**CITY OF PORTLAND, MAINE  
DEPARTMENT OF PUBLIC WORKS  
OPERATIONS/ENGINEERING - INSPECTIONS**

**TO:** Bill Bray, P.E., Director of Public Works  
**FROM:** Nancy L. Knauber, Associate Engineer  
**DATE:** July 13, 1998  
**SUBJECT:** Redlon Park, Weekly Report - Inspected July 13, 1998  
Ric Weinschenk - 828 - 3900

TO: Sarah Hopkins, Senior Planner *SB (SO)*  
FROM: Steve Bushey, Development Review Coordinator  
DATE: March 14, 1997  
RE: Redlon Park

**TO:** Sarah Hopkins, Senior Planner  
**FROM:** Tony Lombardo, Project Engineer *ALH*  
**DATE:** March 13, 1997  
**SUBJECT:** Redlon Park - P.R.U.D. Subdivision

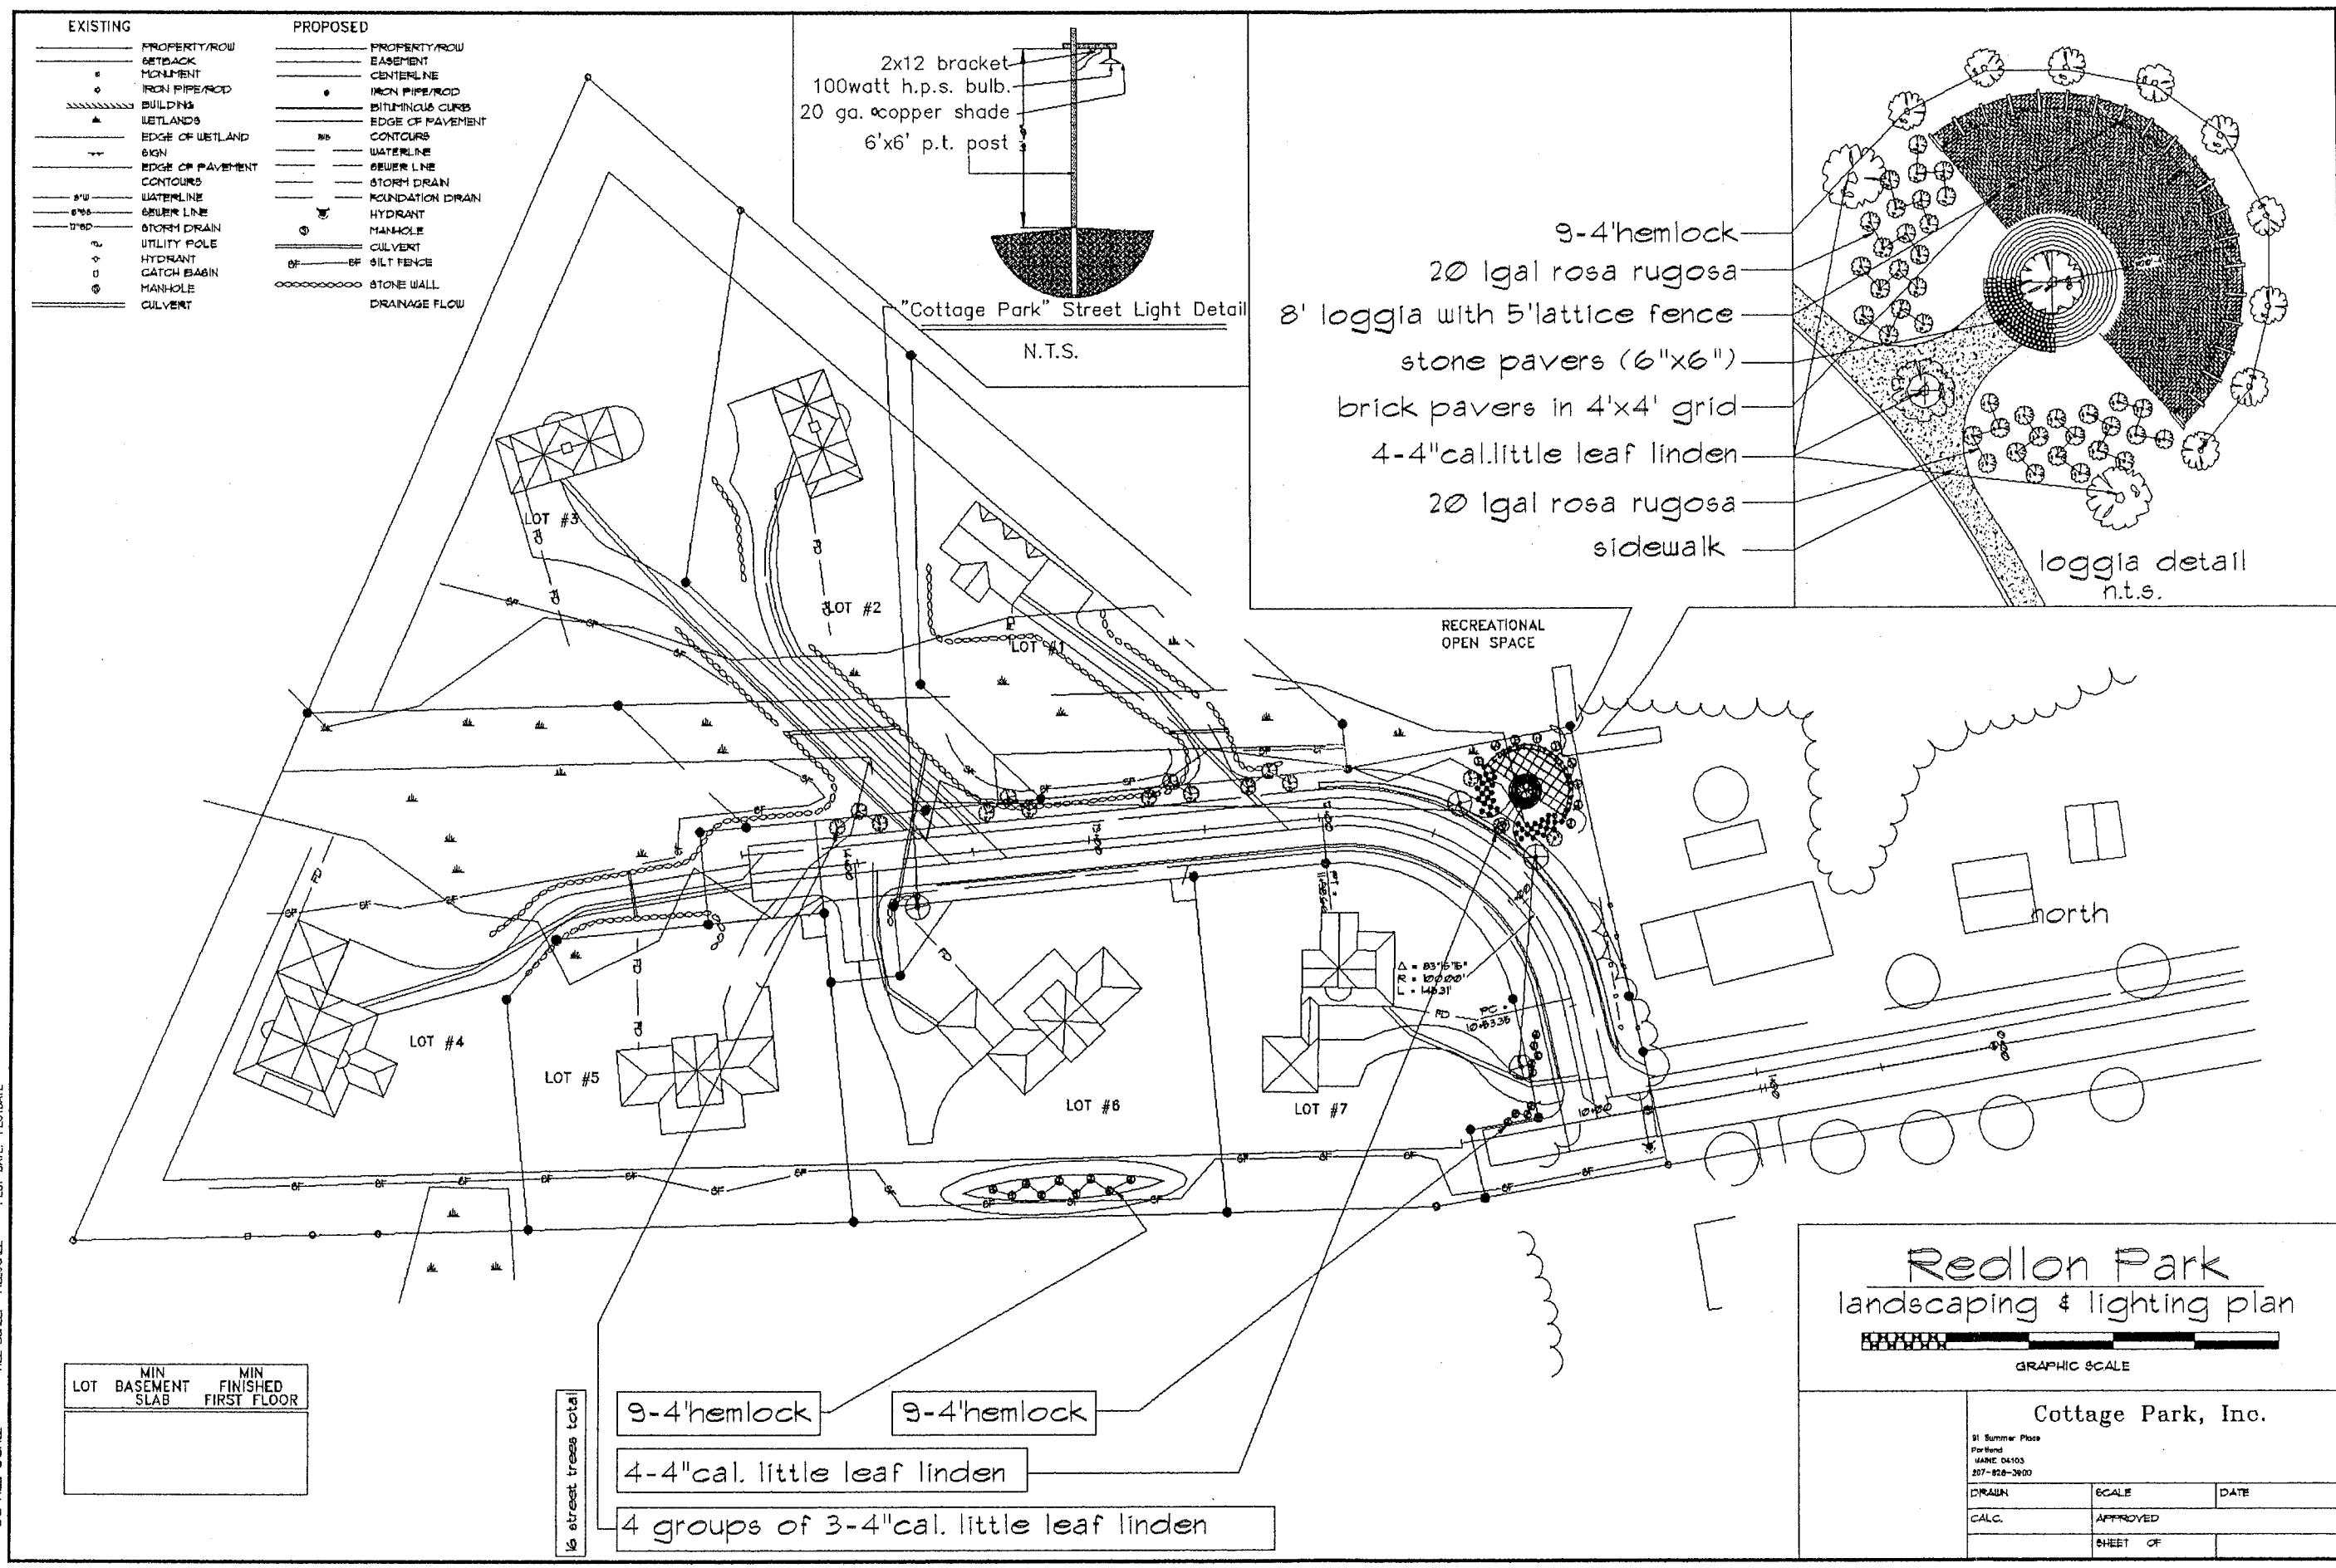
#### Sheet D1/Stormwater Management Report

1. The total predevelopment and postdevelopment water shed sizes are not the same (4.99 acres vs. 4.8 acres). Is this accurate?
2. The predevelopment versus postdevelopment time of concentration for subcatchment 4 and 40 vary significantly (3.2 min vs. 24.5 min.). The applicant should check the data entry for the predevelopment subcatchment 4.
3. As stated earlier the applicant should provide the ponding limits for each culvert used in the computations. The applicant should also provide the anticipated finish floor elevations for each house lot.
